Item No. **Report of the Interim Director of Planning, Regeneration & Public Realm**

Address: 14 DEVON WAY HILLINGDON

Development: Change of use from C4 house in multiple occupancy (HMO) to sui generis HMO for 7 bed and 7 persons with no external alterations.

LBH Ref Nos: 27994/APP/2021/3581

SITE PLAN (1:500)

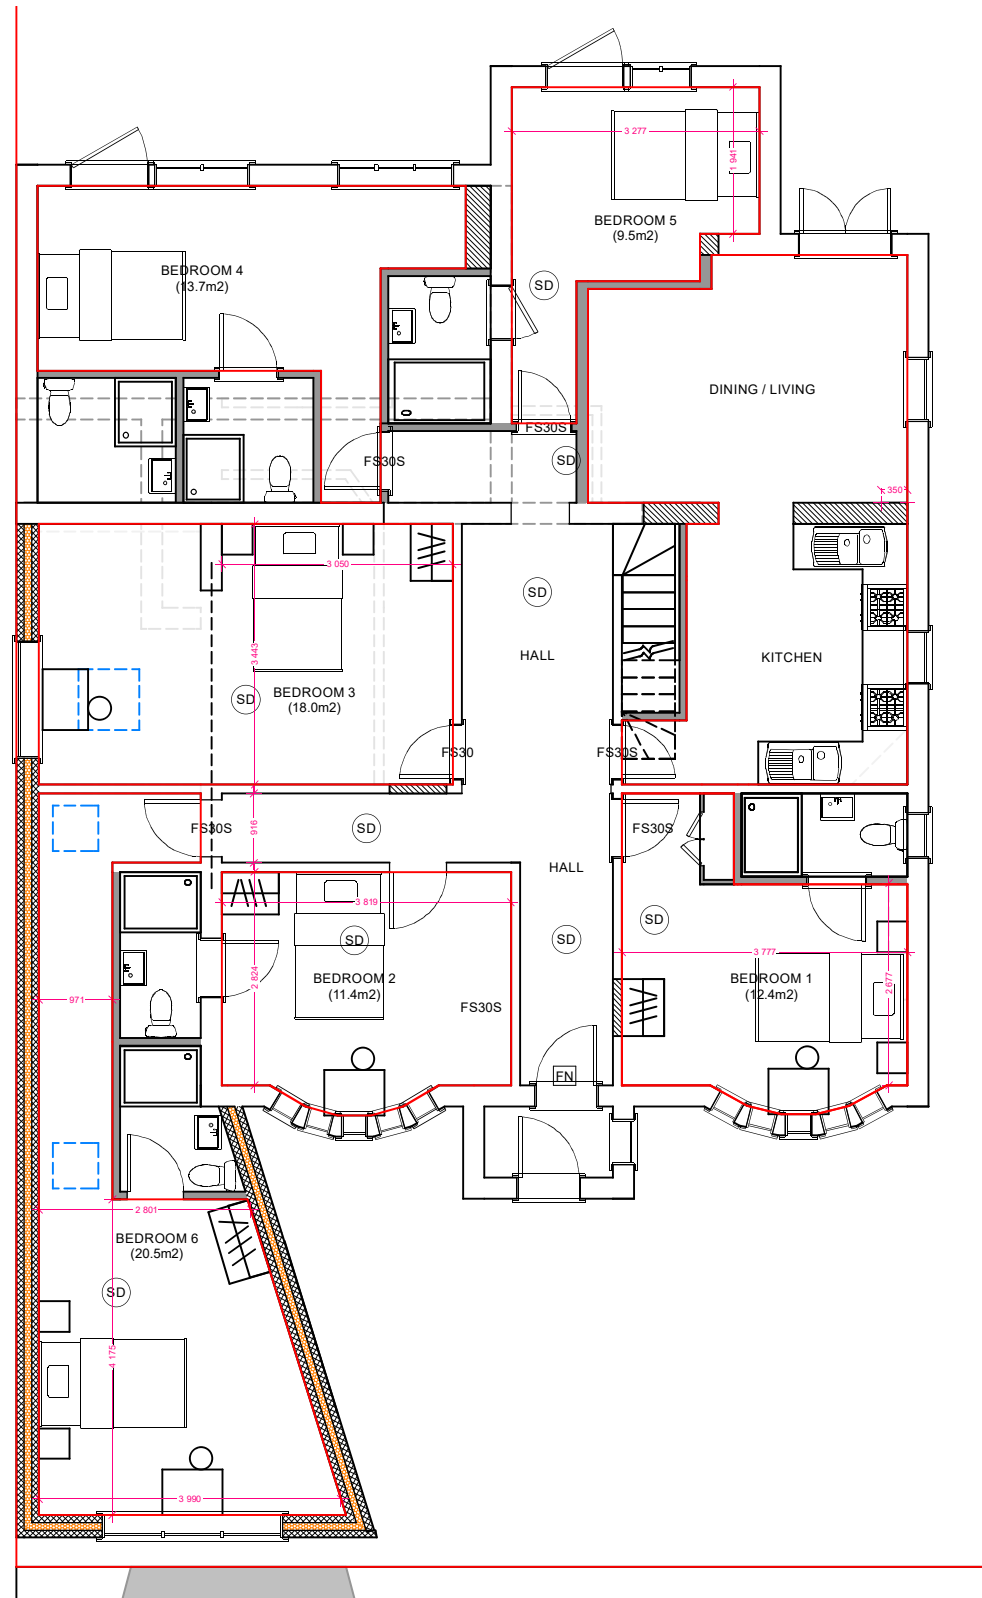
- Submitted plans are incorrect as there is not four on-site car parking spaces (in reality there is only

The application site benefits from a front forecourt that can accommodate 2 vehicles. On-street parking in the vicinity of the site is regulated through single yellow lines a residents' parking permit scheme (HN1). Due regard has been given to the former use of the property as small HMO accommodating up to six persons. However, in the absence of a signed legal agreement to prohibit occupiers from obtaining street parking permits, it is considered that the existing large HMO accommodation coupled with the self-contained residential unit within the outbuilding, would likely park their vehicles on the nearby roads. The site has a PTAL rating of 2 (Poor) which means its likely that occupiers of the site would be reliant on private vehicles as a means of transport. Thereby, exacerbating the pressure for street parking. A parking impact assessment has not been submitted to demonstrate that the street parking spaces on nearby surrounding roads has sufficient capacity to accommodate the additional parking demand generated by the development. Thus, leading to increased instances of dangerous or illegal parking. This in turn, would result in congestion and prejudice highway safety.

PROPOSED G/F (1:100)

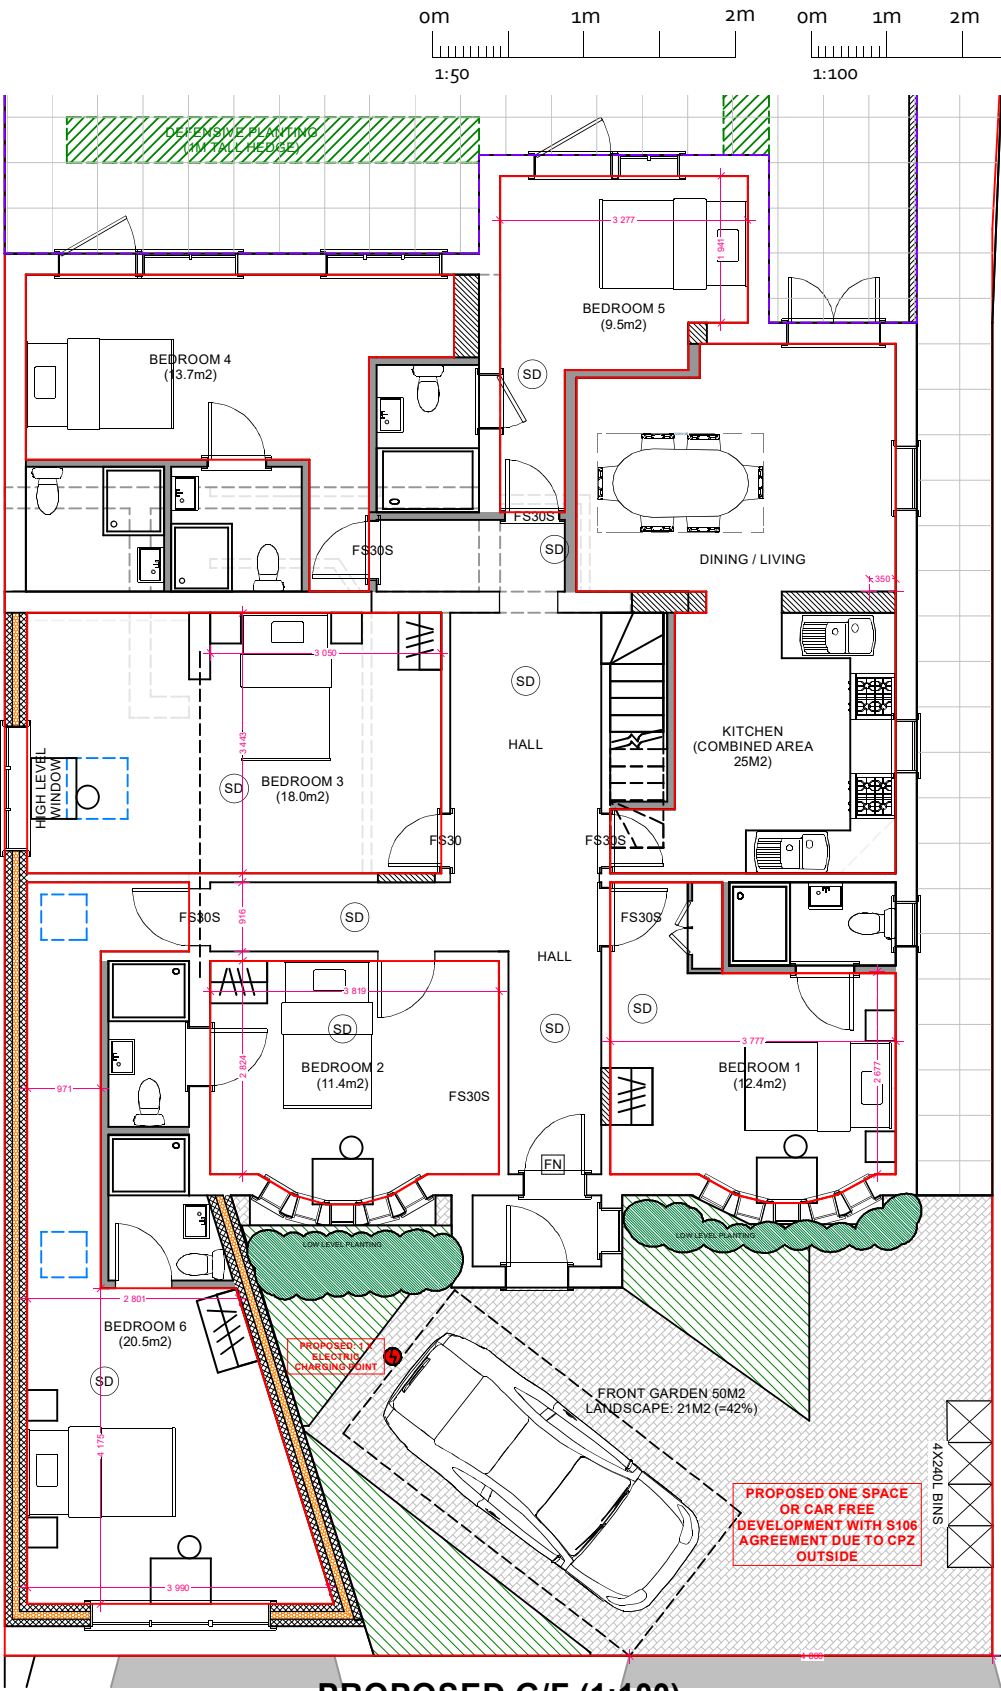
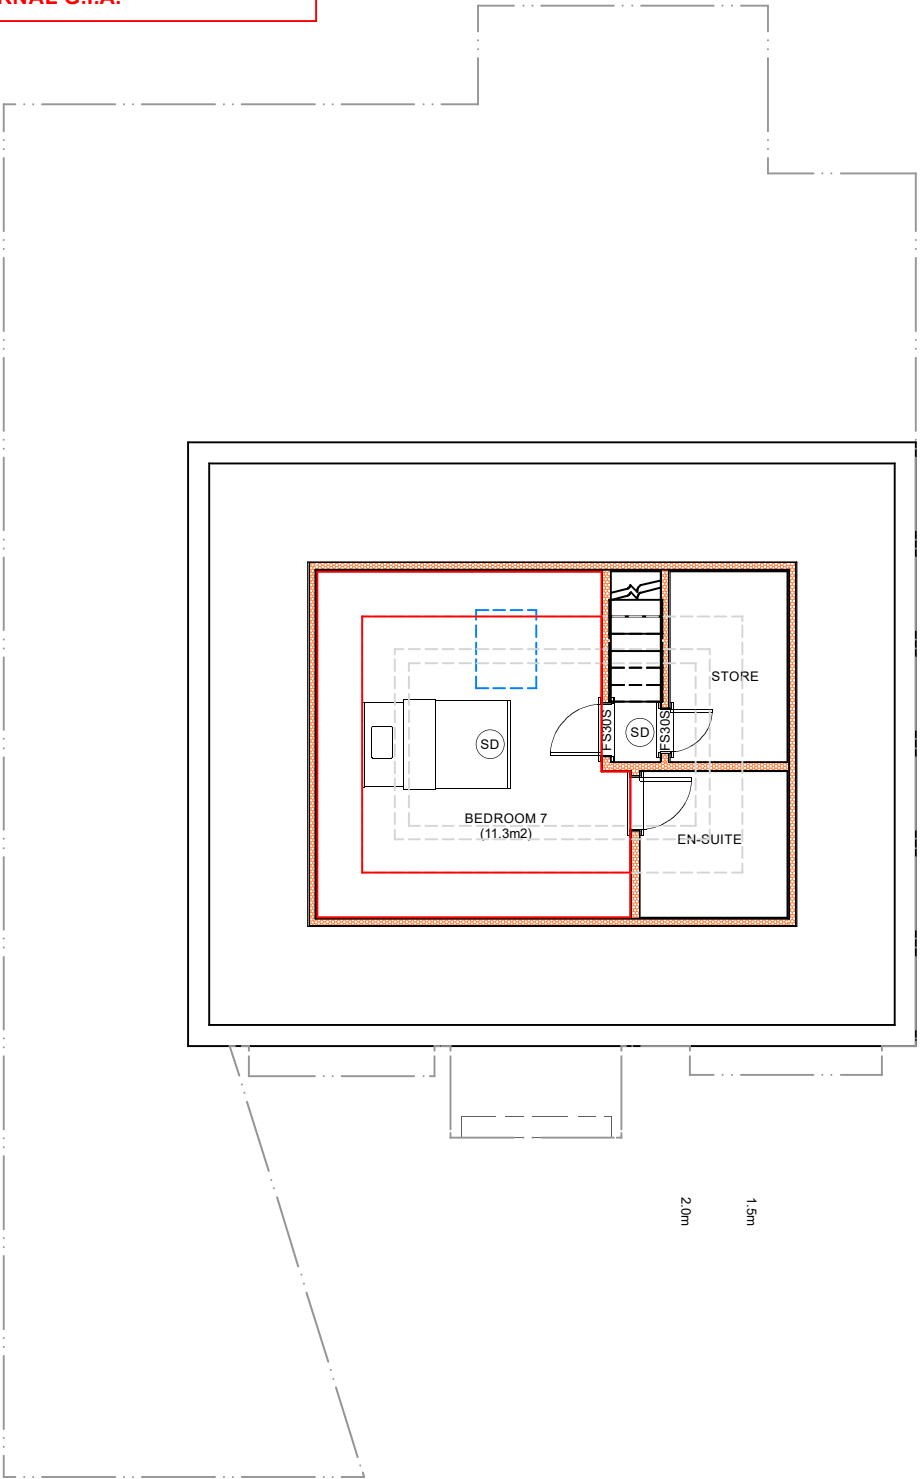
Each of the 7 HMO of the bedrooms benefits from their own en-suite shower rooms and a kitchen cabinet with no sink. During the officer site visit it was observed that none of the 7 rooms contain any cooking facilities (or microwaves). The submitted plans shows a communal kitchen and dining room area on ground floor level, and this was confirmed during the site visit. Having regard to the 'Gravesham' Court Judgement, it is considered that the rooms do not constitute as a self-contained units and that the use of the main property is a large HMO (Sui Generis).

It is acknowledged that the Hillingdon Local Plan: Part 2 - Development Management Policies (2020) does not contain any specific standards in respect to HMO. The submitted plans shows that the seven bedrooms which are each occupied by a single person range between 9.5 sqm and 20.5 sqm, which is considered to be acceptable when compared to the bedroom standards prescribed in parts 3 and 4 of Policy D6 of the London Plan. The kitchen/dining/living room has a floor area of 25 sqm which is considered to be of a sufficient size to meet the needs of the seven occupants.

Although Bedrooms 3 and 7 have limited outlook, this is considered, on balance, to be acceptable having regard to the former use of the property as a small HMO. Similarly, the relationship between the windows serving Bedrooms 4 and 5 and the communal garden would not be significantly different to former use of the property as a small HMO. With an area of 135 sqm, the communal rear garden for the occupiers of the HMO is considered to provide an adequate provision of external amenity space.

ANNEX - R/O 14 DEVON WAY

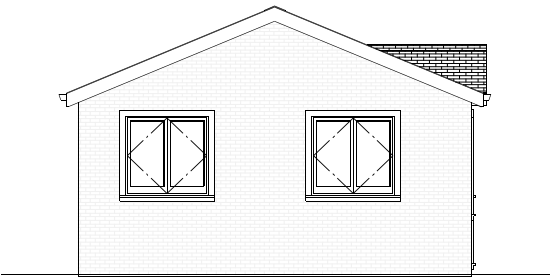
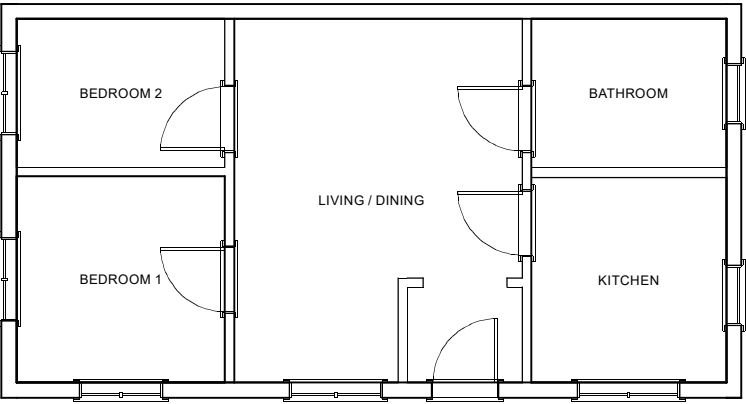
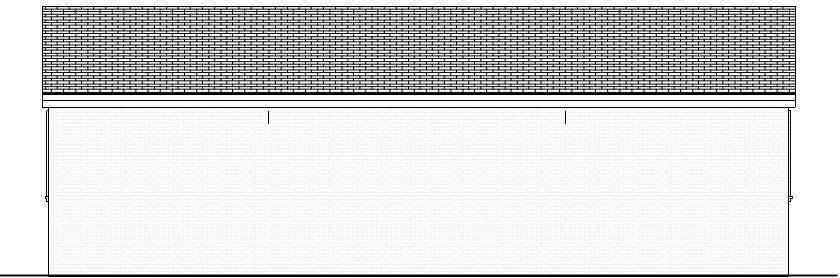
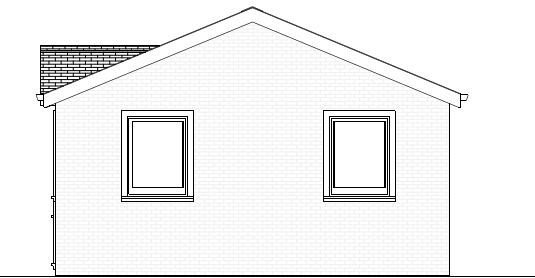
In this case, the existing brick built outbuilding at the site contains a kitchen with a sink, oven and stove; an open plan living/dining room; a shower room with a toilet and hand basin; and two bedrooms. It is therefore considered that the outbuilding has all the day-to-day facilities for it to be used as a self-contained residential unit. There is independent access to the outbuilding through the side passageway. Furthermore, the outbuilding has been sectioned off from the main property by the erection of timber fencing running along its front elevation. Given these circumstances, it is considered that the outbuilding is a self-contained residential unit and as such a separate planning unit has been created.

By reason of its poor levels of outlook, the existing outbuilding (which is being used as self-contained residential unit), has resulted in a substandard form of internal living accommodation to the detriment of the amenity of its occupiers. The proposal, therefore, conflicts, with Policy DMHB 16 of the Hillingdon Local Plan: Part 2 - Development Management Policies (2020), Policy D6 of the London Plan (2021) and the National Planning Policy Framework (2021).

The existing outbuilding (which is being used as a self-contained residential unit) has no private useable amenity space provision, and has therefore resulted in a substandard form of external living accommodation to the detriment of the amenity of its occupiers. The proposal, therefore, conflicts, with Policy DMHB 18 of the Hillingdon Local Plan: Part 2 - Development Management Policies (2020), Policy D6 of the London Plan (2021) and the National Planning Policy Framework

The rear outbuilding has a gross internal area of 45 square metres, which falls significantly below the London Plan's minimum 61 sqm requirement for a 2 bedroom, 3 person dwelling. Given the figures in Table 3.1 of the London Plan are minimum standards which are intended to act as a benchmark for high quality design, the shortfall in the internal floor space provision is not appropriate. The front elevation habitable windows face directly towards fencing measuring 1.8metres, which is positioned 1 metre away. The side windows serving the bedrooms within the outbuilding face directly towards the side boundary treatment. It is therefore considered that outbuilding provides unsatisfactory living conditions for its occupiers, in terms of inadequate floor space and poor outlook. It cannot be argued that the existing fencing could be removed as this would give rise to a loss of privacy and overlooking issues between the occupiers of the outbuilding and HMO (which contains habitable windows within its rear elevations)

There is a small section of hardstanding adjacent to the northern flank wall of the outbuilding. However, this area is not considered to constitute as private useable amenity space as its covered in hardstanding and adjoins the side passageway leading to the rear garden of the HMO. Consequently, the outbuilding has no external amenity space provision, which conflicts with the minimum 60 square metre requirement found in Table 5.3 of the Hillingdon Local Plan (Part 2).
